Rezoning Transportation Analysis

Petition Number: #2022-107

Date	Description
11-28-22	First Review (IW)

REZONING PETITION 2022-XXX
SCALE: 1"=20'

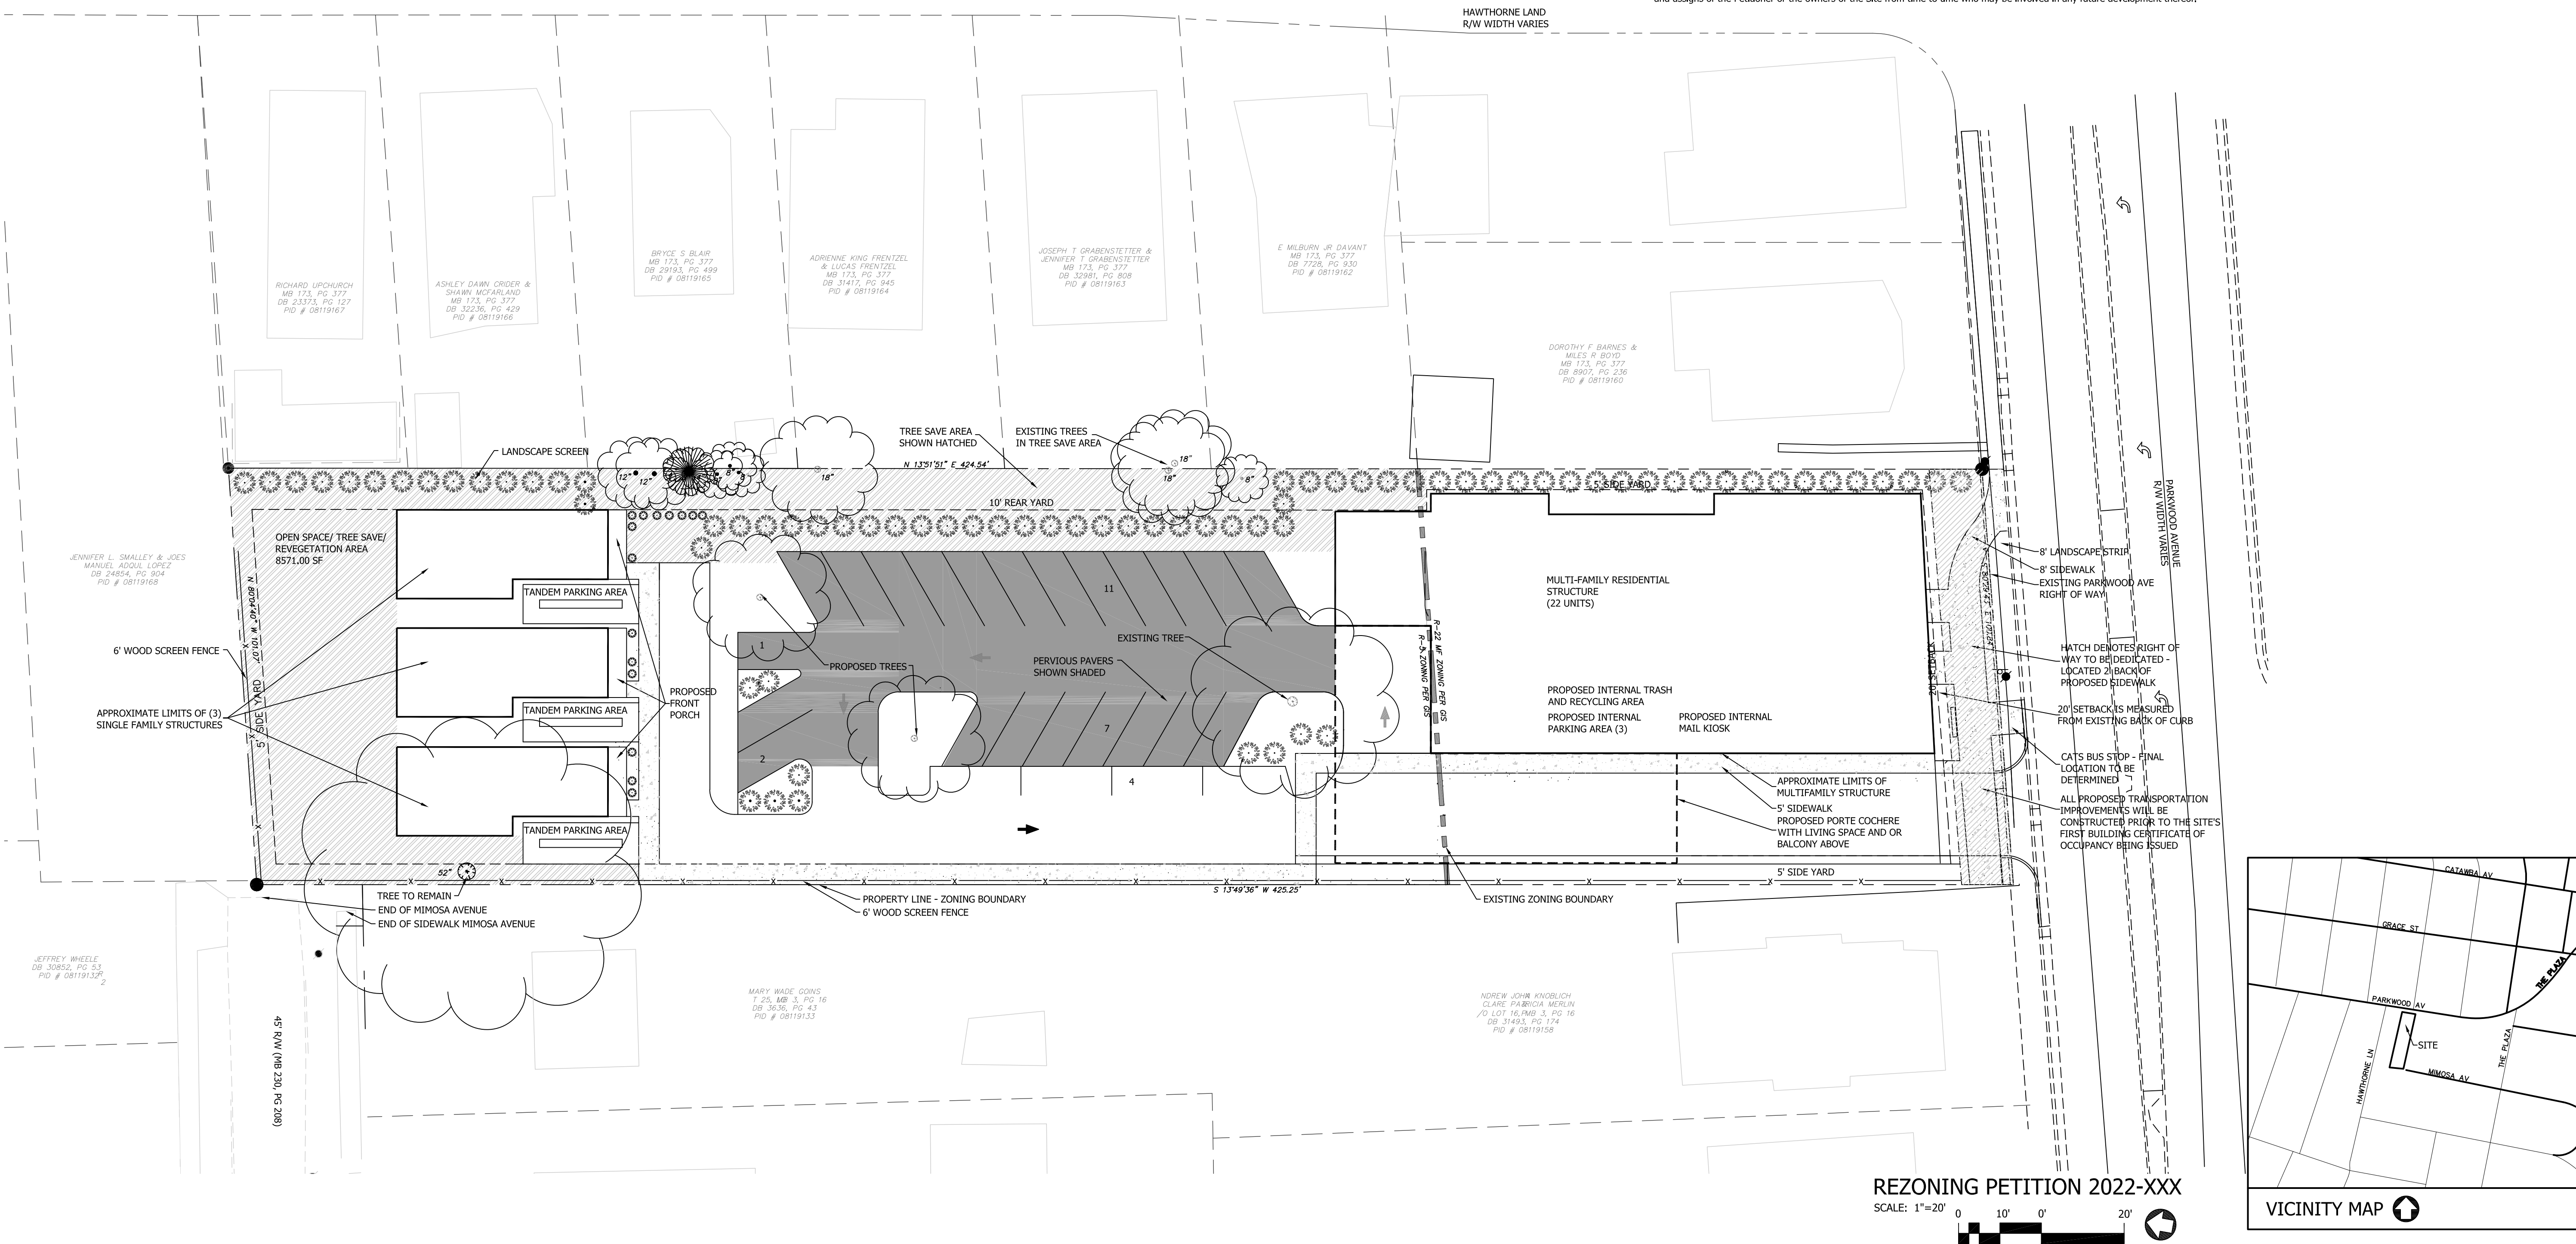
1. **Curbline:** The proposed zoning district has a setback measured from back of the existing or proposed future curblines.
 - a. **Parkwood Avenue:** Location of curb and gutter is 38 feet from centerline.

Label and dimension the curb and gutter from the centerline for each road on the site plan.

3. Revise site plan and conditional note(s) to commit to dedicate 56 feet of right-of-way from the road centerline. The site plan shall label and dimension the right-of-way from the road centerline.
4. CDOT requests the site plan and conditional note(s) revisions are needed to commit to connect sidewalk near single family structure to existing sidewalk on Mimosa Avenue.

5. Site plan and conditional note(s) revisions are needed to commit to extending the 8' sidewalk to property line along Parkwood Avenue.
